North West Rail Link (NWRL)

Environmental Impact Statement 2

Response to NWRL EIS2 -

Group Response in regards to the use of Robert Road, Cherrybrook

Figure 6.11 Cherrybrook Station - Indicative layout

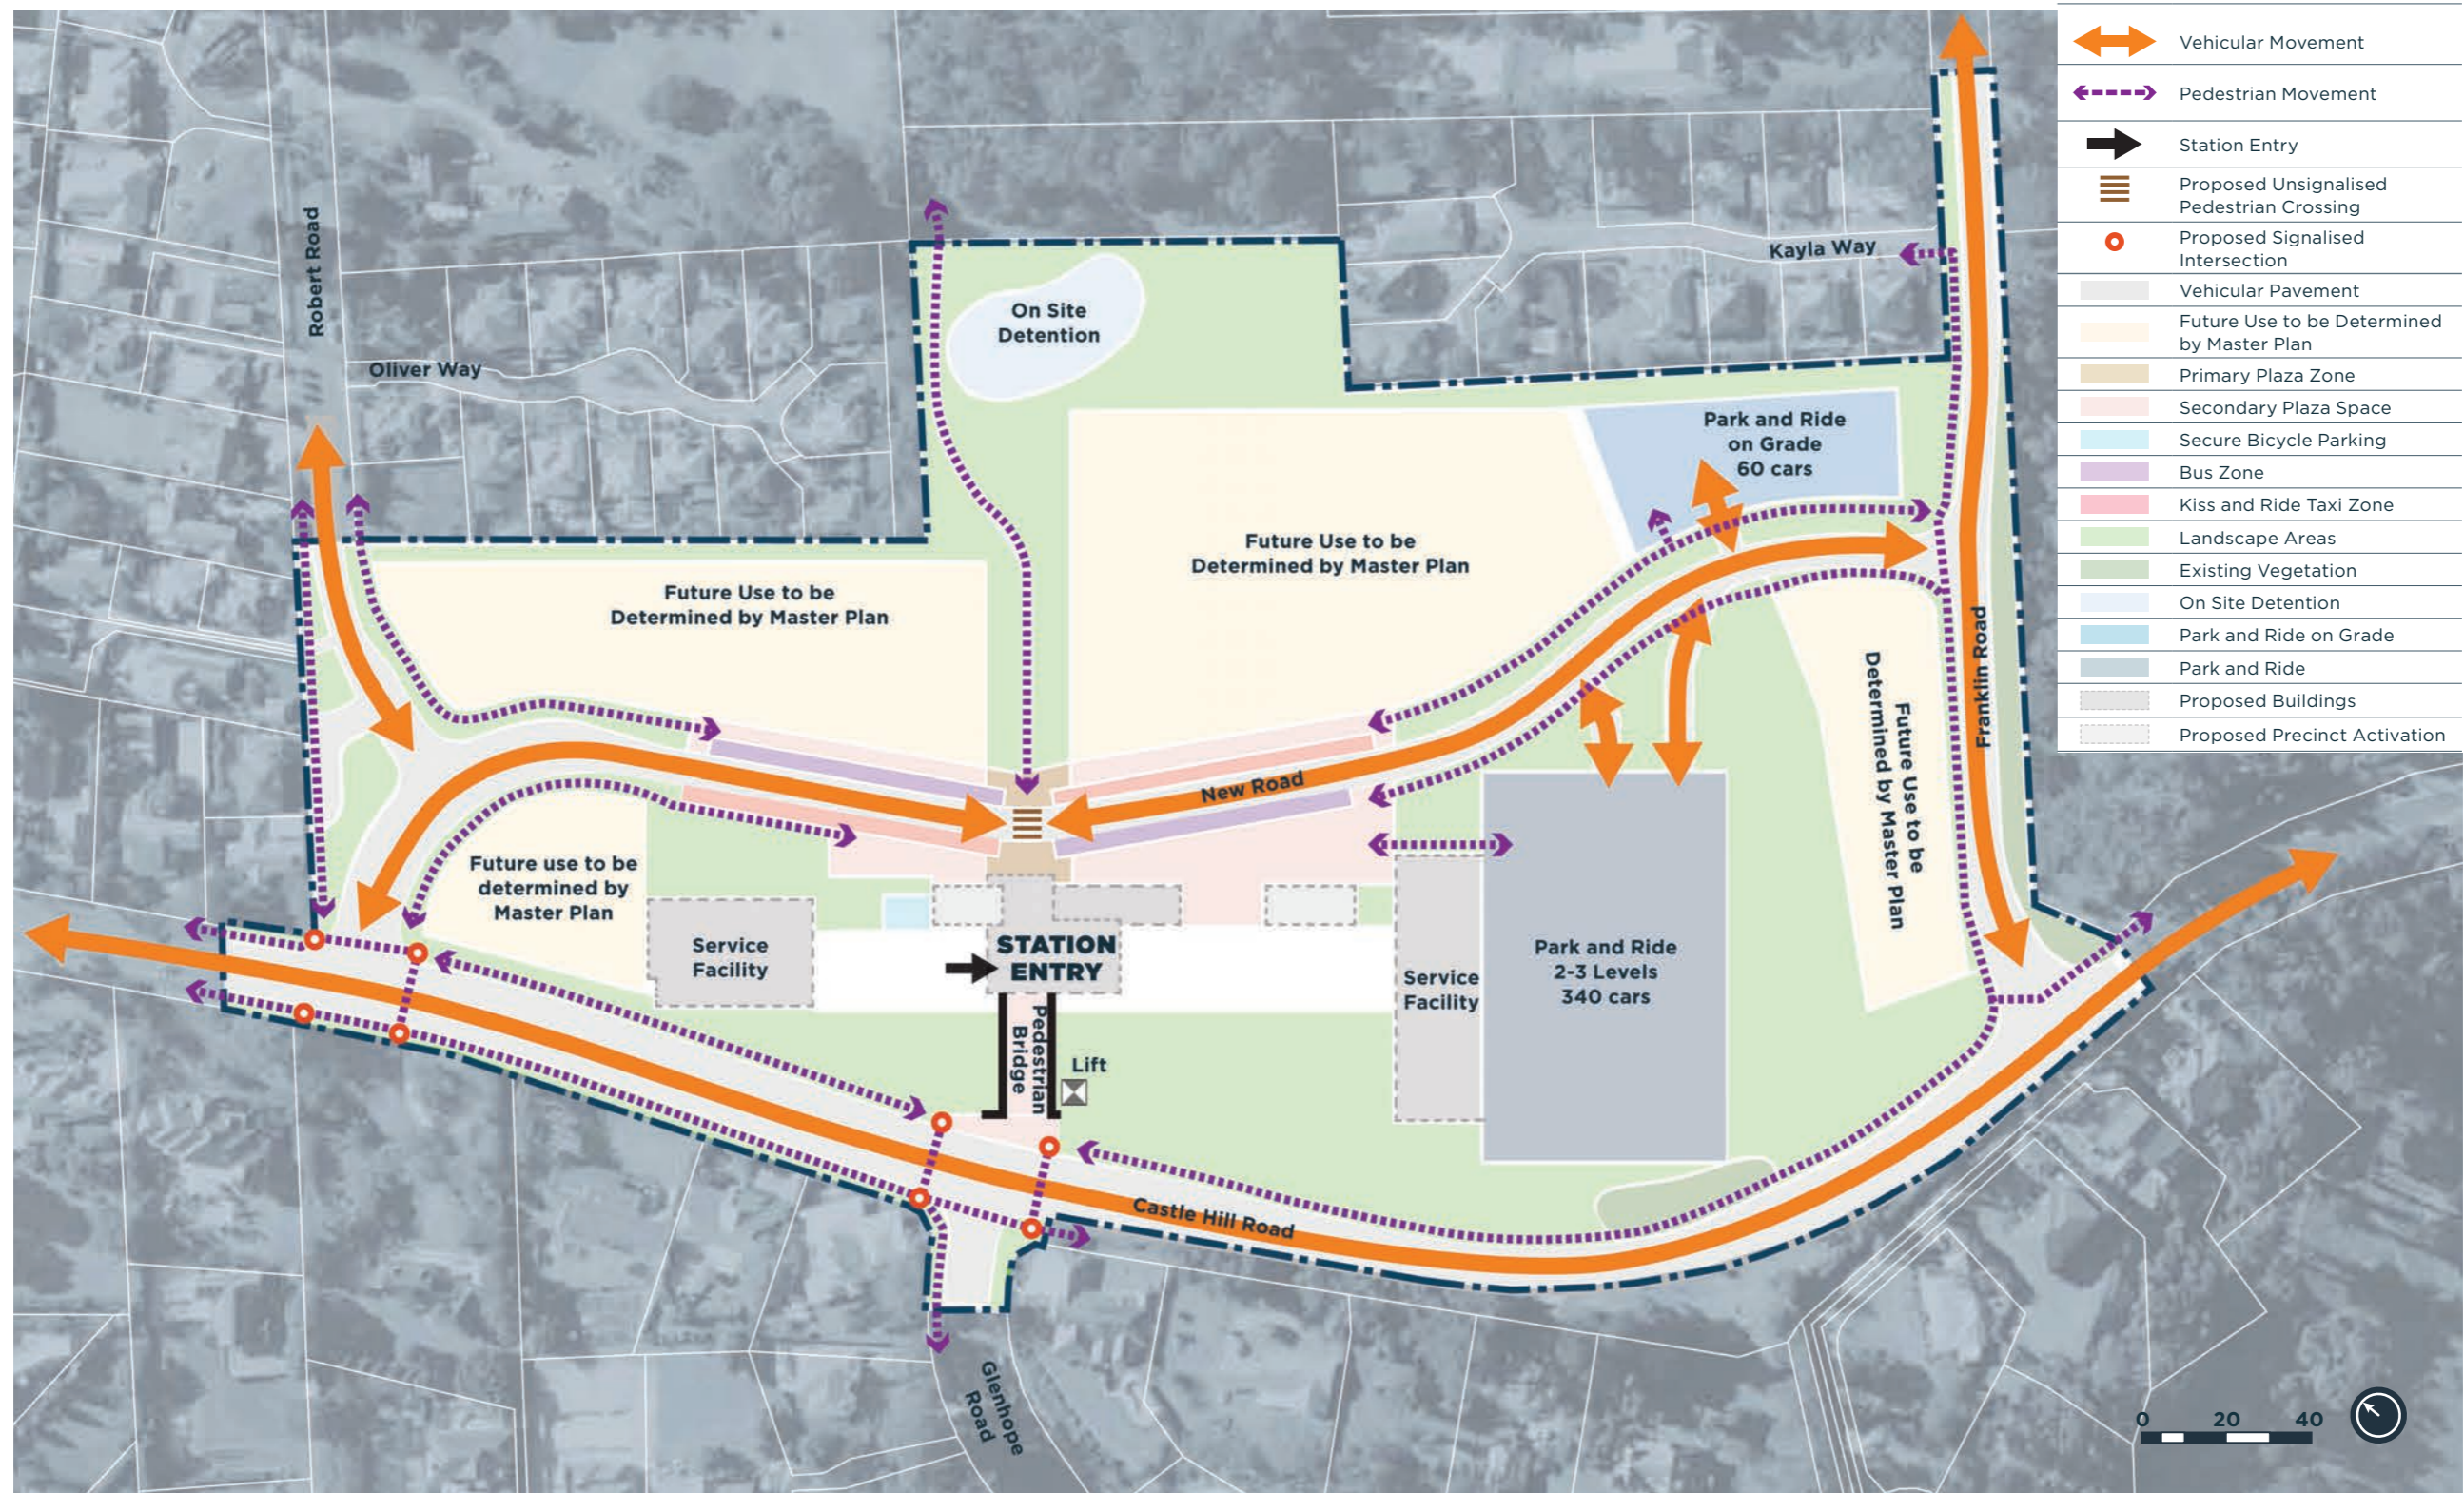
Environmental Impact Statement 2 provides a proposal as to the protection of the homes within Our Group against the Cherrybrook Station Precinct which will be located directly across the road from our homes. A diagram of this proposal is attached in Appendix B.

In a nut shell, the protection proposed in Appendix B is not only inadequate but with respect, in our opinion, provides a somewhat chaotic solution to those homes which will be most impacted by the Cherrybrook Station Precinct.

We would like to propose and are requesting that an alternate solution to that in Appendix B, be adopted. In particular, our alternate solution is attached in Appendix C and Appendix D.

1. Removing the NWRL proposed island of trees directly out the front of 1 Robert Road - as marked A on Appendix B.
2. Extend the proposed NWRL cul-de-sac road to allow vehicular access for the houses of 210 Castle Hill Road (also referred to as 1c Robert Road) and 1b, 1, 1a, 1/3, 2/3 and 3/3 Robert Road into and out of the cul-de-sac – as marked C on Appendix C.

5. Move the portion of Robert Road which has been proposed by NWRL as the entry point into the Cherrybrook Station spine road, as far east as possible – as marked A on Appendix C.

1. The southern end of Robert Road should be closed off prior to the commencement of the construction phase;
2. The cul-de-sac road be constructed prior to the commencement of the construction phase in order to maintain a nominal amount of on street parking for residents in Our Group during the construction phase;
